Recommendation Report for Planning Permission for Works or Extension to a Dwelling

REF NO: FG/45/18/HH

LOCATION: 25 Upper West Drive
Ferring
BN12 5RG

PROPOSAL: Single storey front, side & rear extensions (resubmission following FG/92/17/HH).

Drawing No.
1336/P02

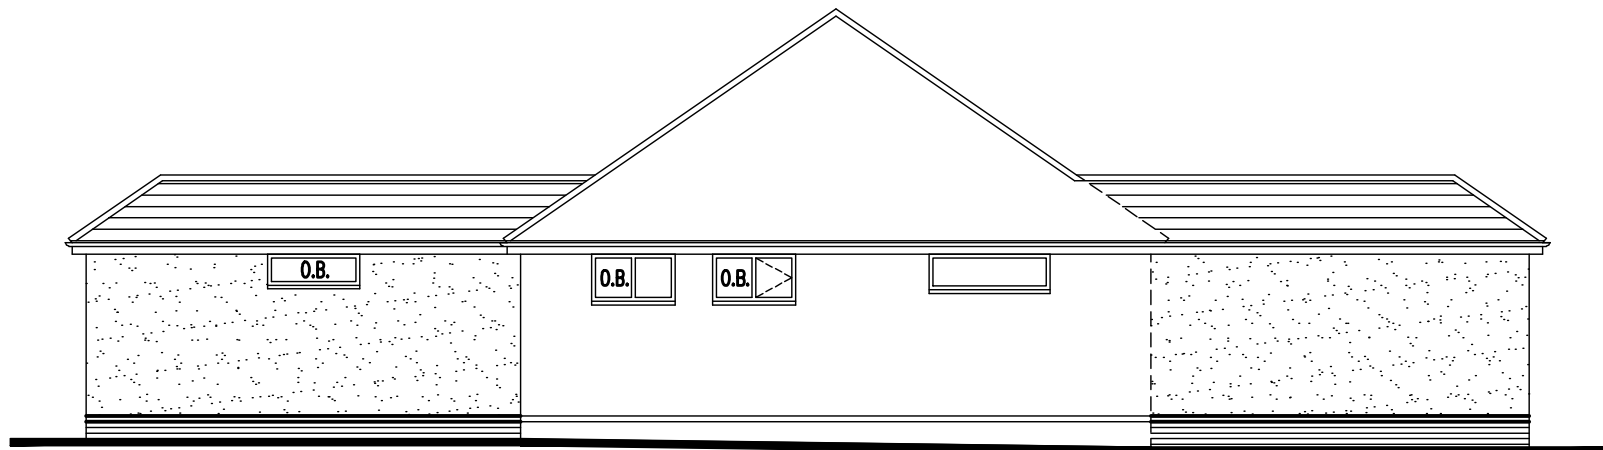
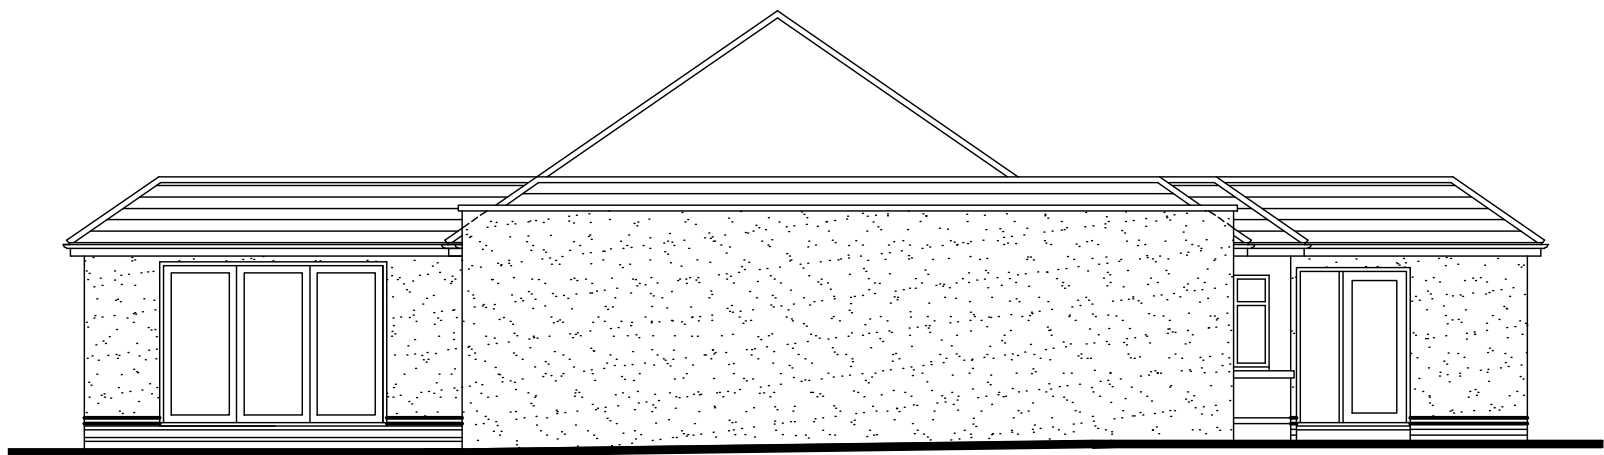
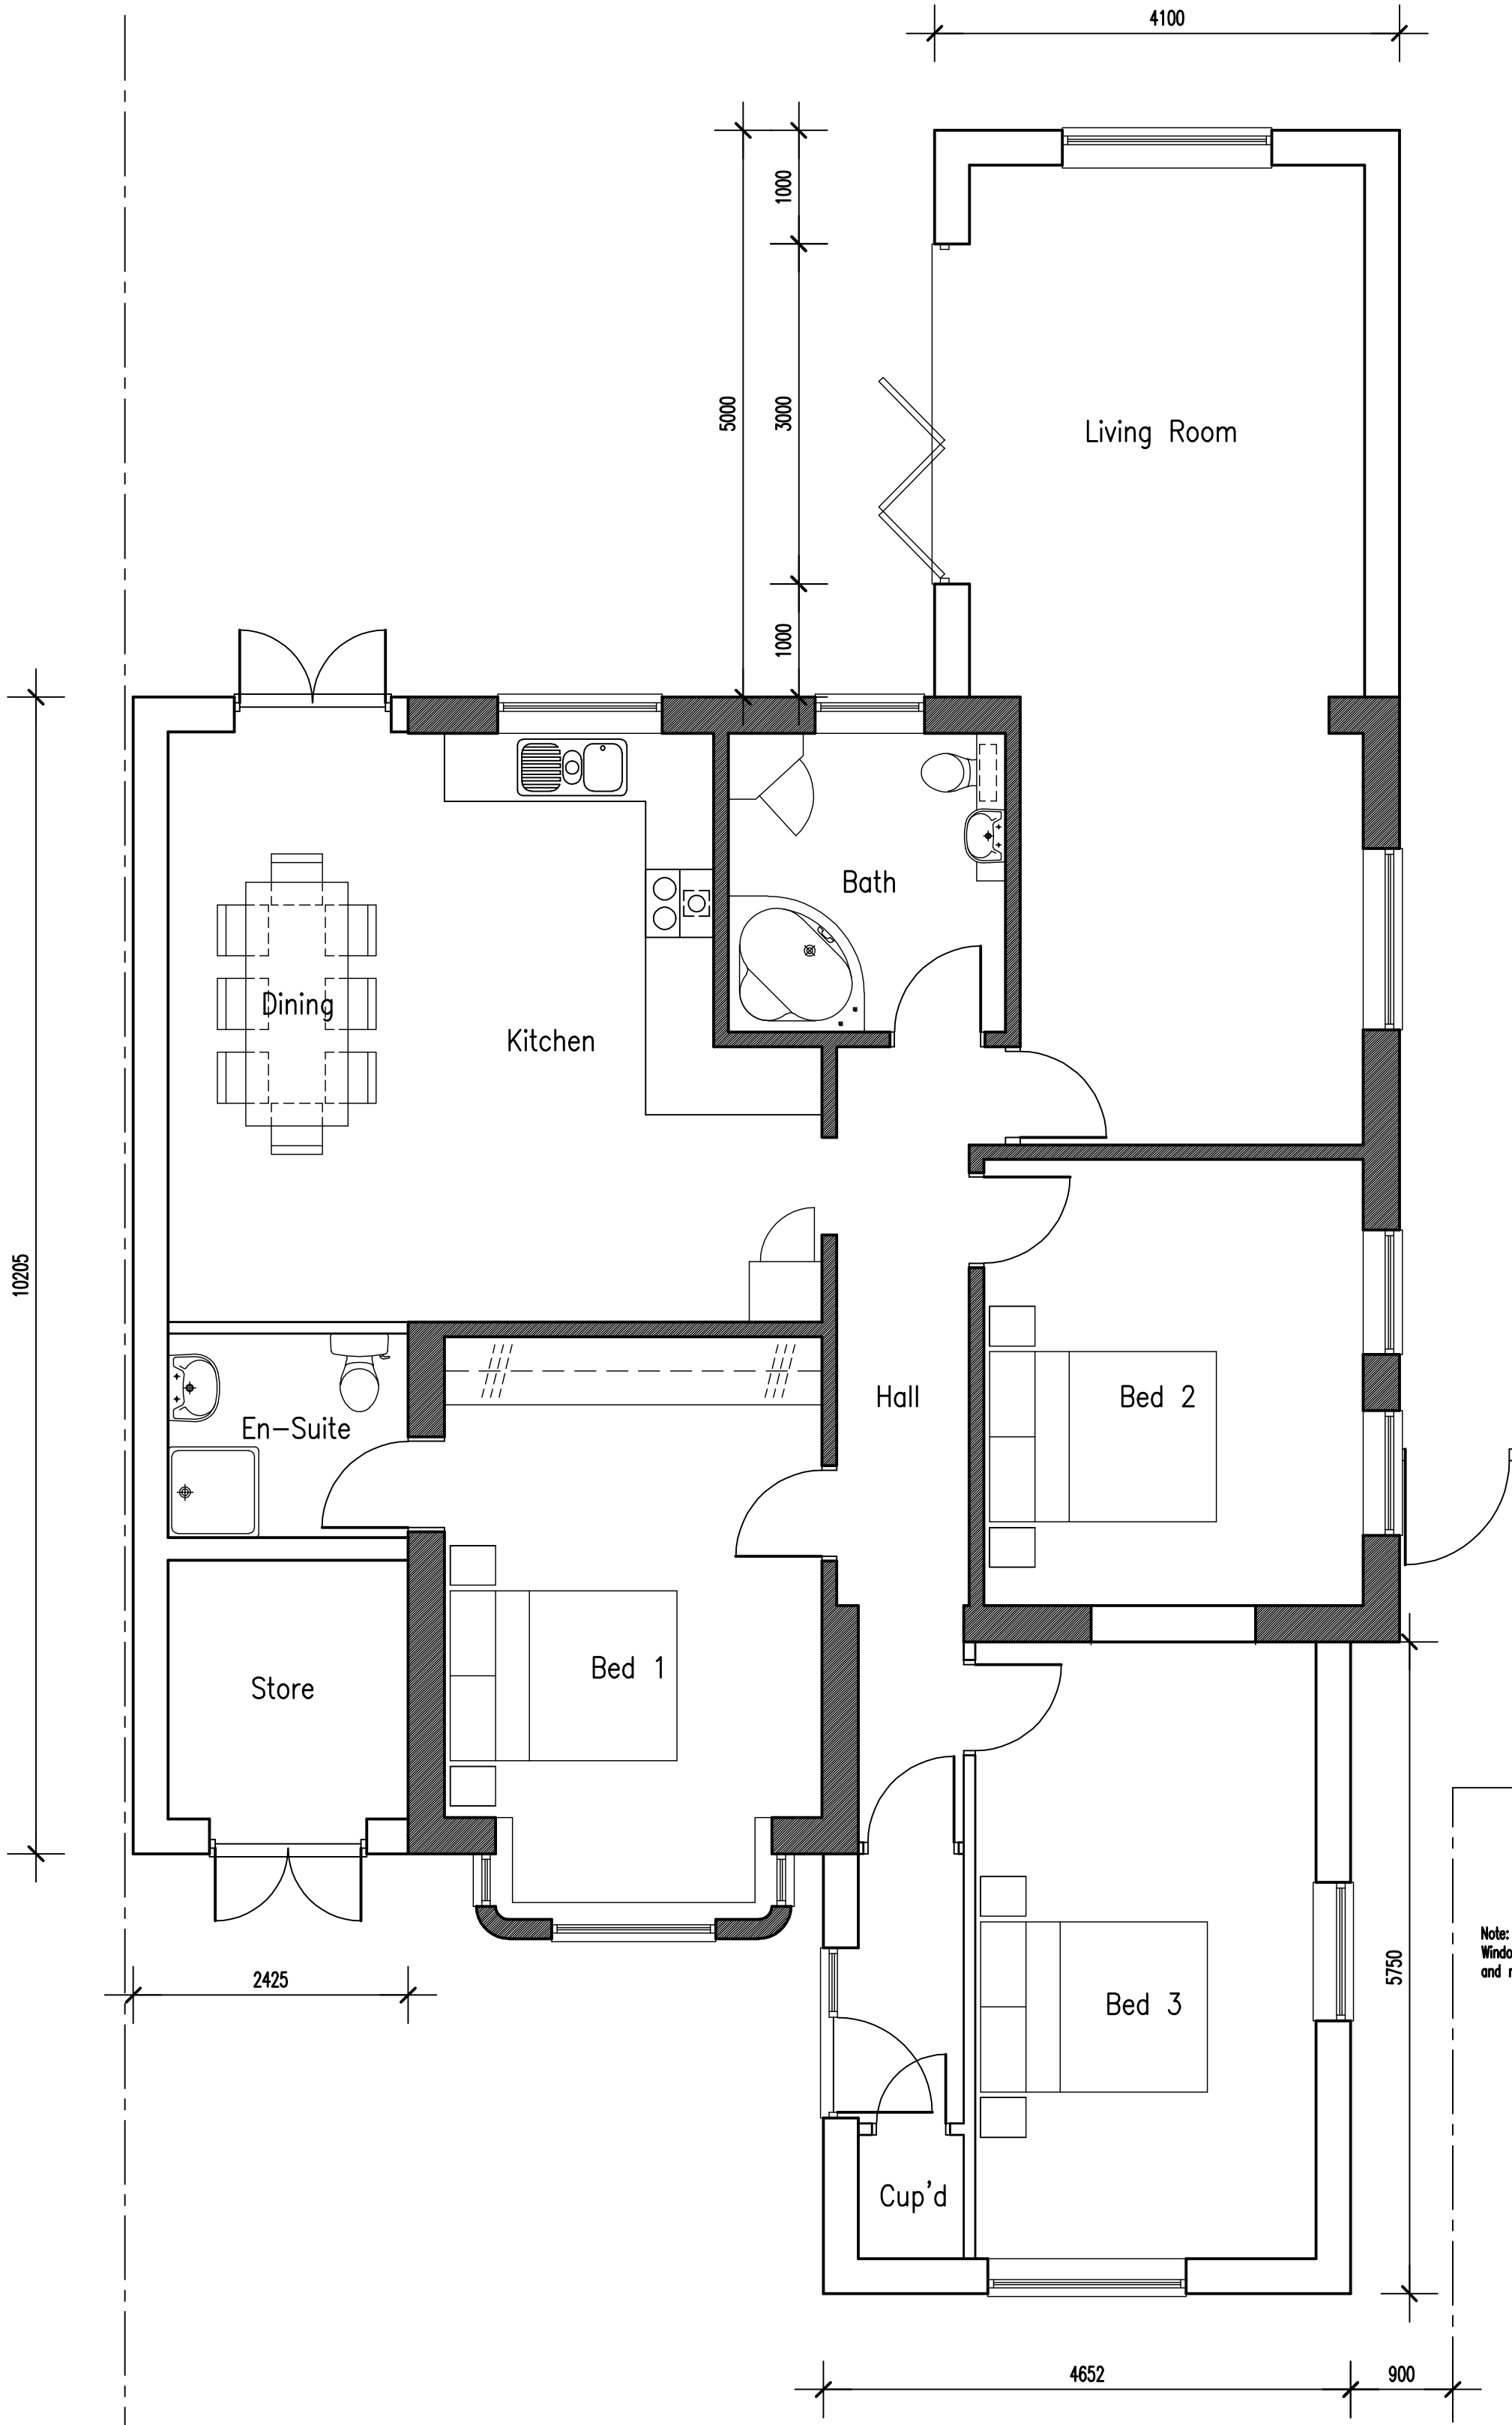
-A reduction in width in the patio doors on the south elevation of the rear extension.

-A window instead of patio doors on the rear of the rear extension

- The replacement of 2 high level windows with one on the side elevation of the front extension facing number 27

-The replacement of 4 high level windows on the side elevation of the original bungalow facing number 27 with three windows, one of which is still high level and the other two have a sill height of 1.4m. All are obscure glazed with only the central window having an opening casement.

The windows in bedroom 2 are shown in the application as opaque with the window towards the front of the property fixed. The installed windows both have openings allowing direct view into my mothers bedroom.

The cill level is lower than the original plan which means my mothers bedroom is directly overlooked. My brother spoke to the builder and from standing at floor level could easily see into my mother's bedroom, he is 5' 7" tall.

The glass is not opaque enough, my mother can see people easily on the other side of the glass.

The main issue is the window towards the front of the property as it overlooks us. We have no objection to the window towards the rear being larger if light is an issue.

Reason: In the interests of amenity in accordance with policies GEN7 and DEV19 of the Arun District Local Plan.
- 4 All the windows on the north elevation of the original dwelling and the front extension hereby permitted shall be obscure glazed and fixed shut with the exception of the 2nd window serving bedroom 2 furthest from the front extension which shall be obscure glazed and consist of at least two lights divided horizontally with only the top light capable of being opened, and all the windows shall be maintained in that condition at all times.
